Recommendation Report for Listed Building Consent for Alterations, Extension or Demolition

REF NO: LU/322/13/L

LOCATION: Toddington House
Toddington Lane
Littlehampton

PROPOSAL: Application for Listed Building consent for the demolition of single storey pantry to north elevation and erection of kitchen extension (resubmission following LU/241/13/L).

NORTH-EAST ELEVATION SCALE 1:100

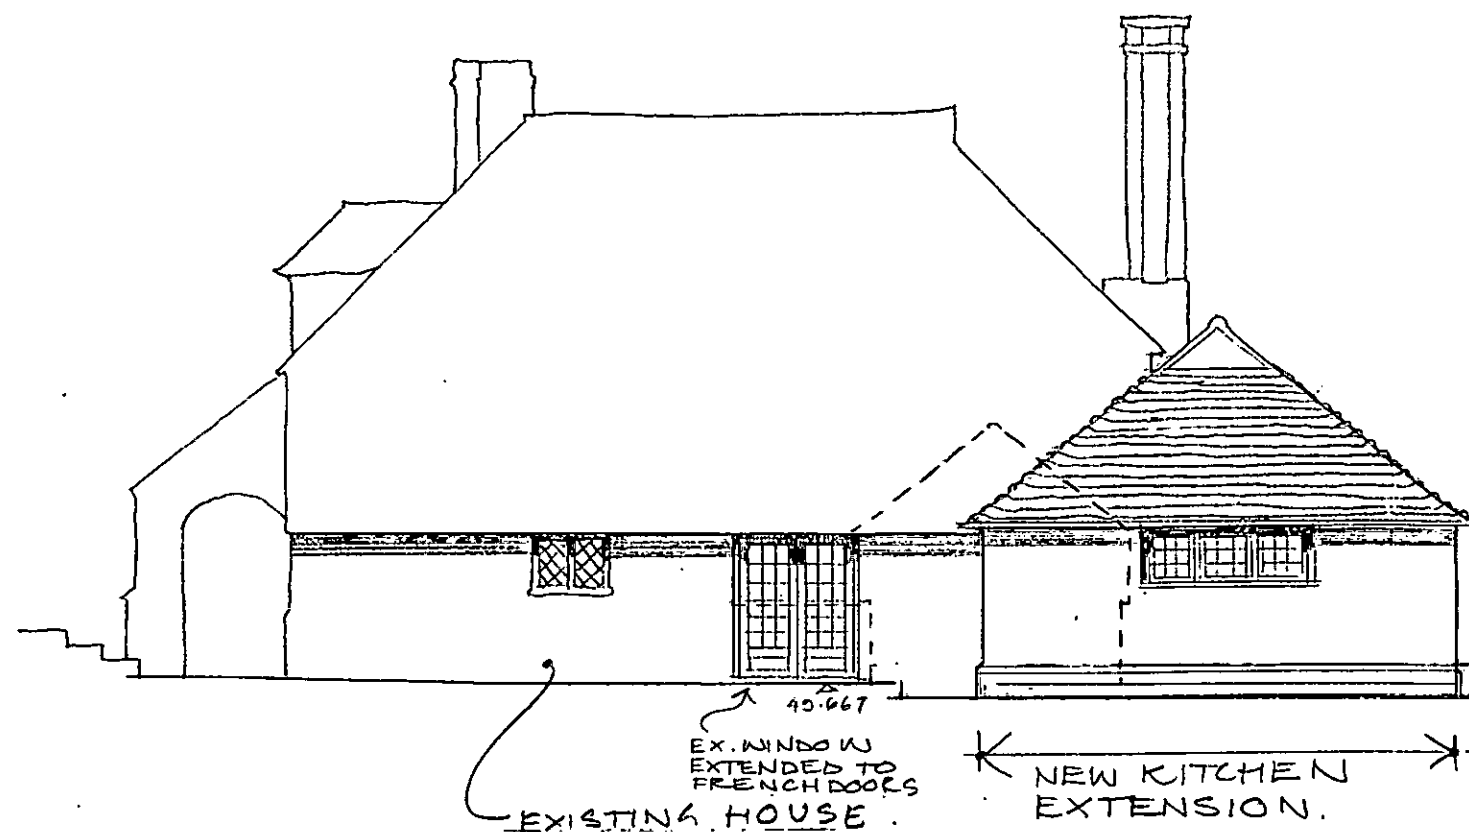
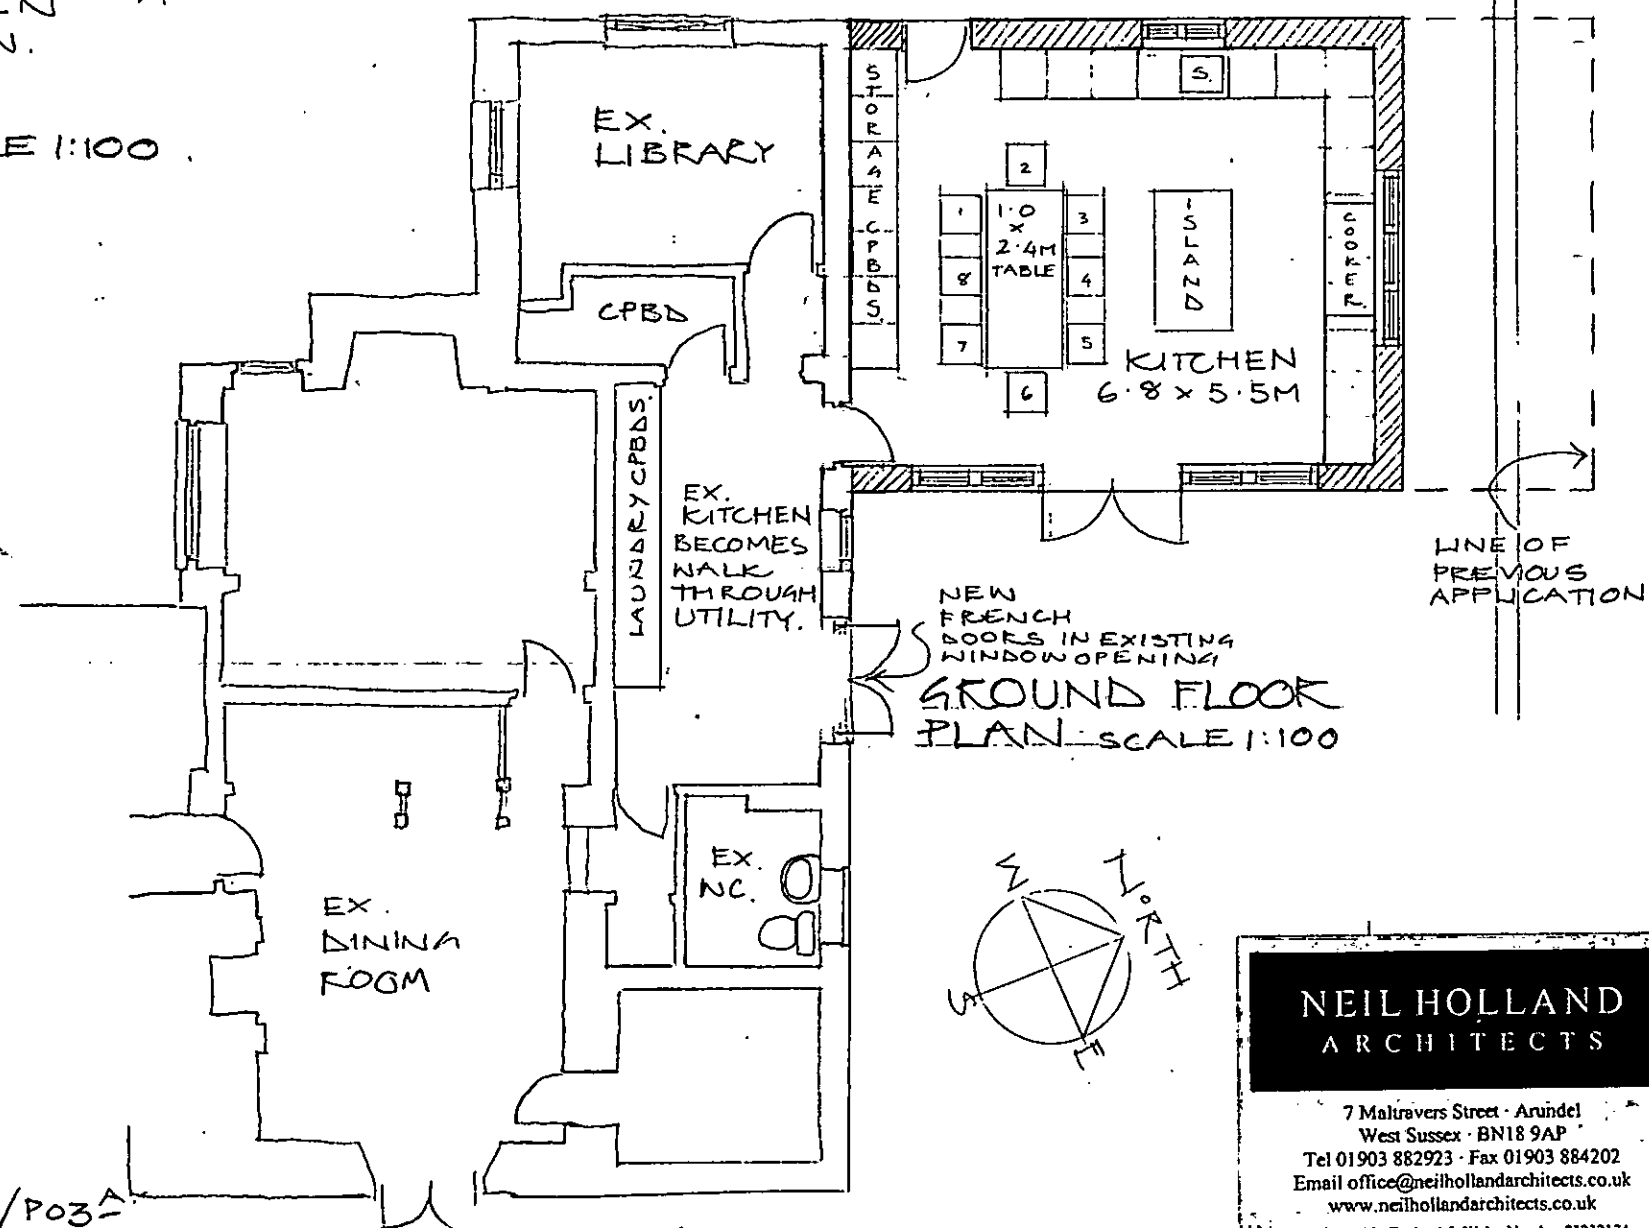
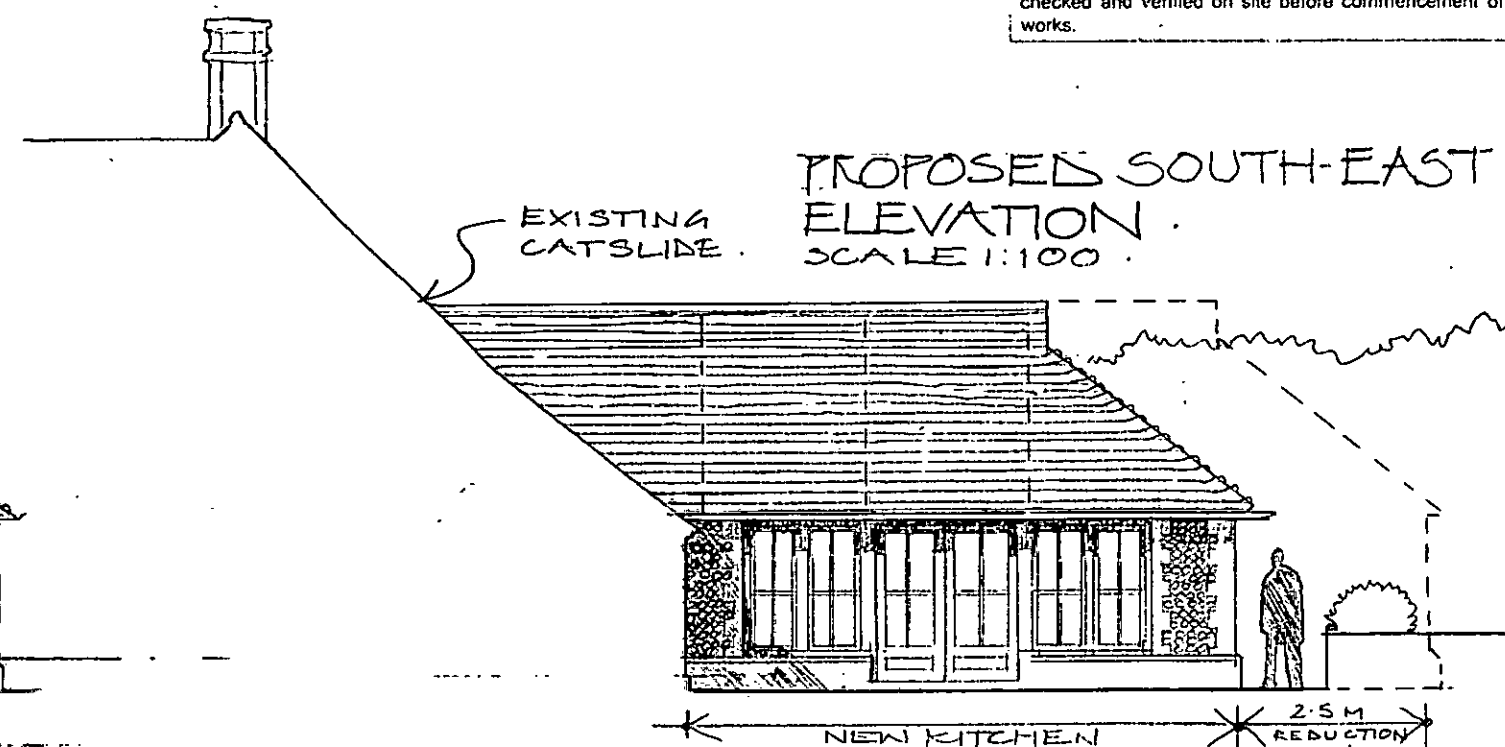
Conditions relating to window and door details, a sample panel showing brick and flint work (flint blocks not acceptable) and a sample roof tile are requested. This should be hand-made and match the existing clay colour.

The proposal is to remove this feature and replace it with a structure which replicates its appearance. The length of the extension has been reduced by 2.5 metres such that it does not significantly increase the bulk of the building to the rear elevation and it would now be a sympathetic addition which would not dominate the building from the side or front elevation within the garden or detract from the understated roof scape. The applicant has satisfactorily justified the scale of the extension in terms of its impact on the listed building. The need for a kitchen extension is accepted. The unwarranted utility element of the extension has been deleted from the application.

- 2 No development shall be carried out unless and until a schedule of materials and finishes including samples for the roof of the proposed extension and a sample panel of brick and flint work have been submitted to and approved by the Local Planning Authority and the materials so approved shall be used in the construction of the extension.

- 3 No development shall be carried out unless and until precise details of proposed windows and doors have been submitted to and approved by the Local Planning Authority and the details so approved shall be used in the construction of the extension.
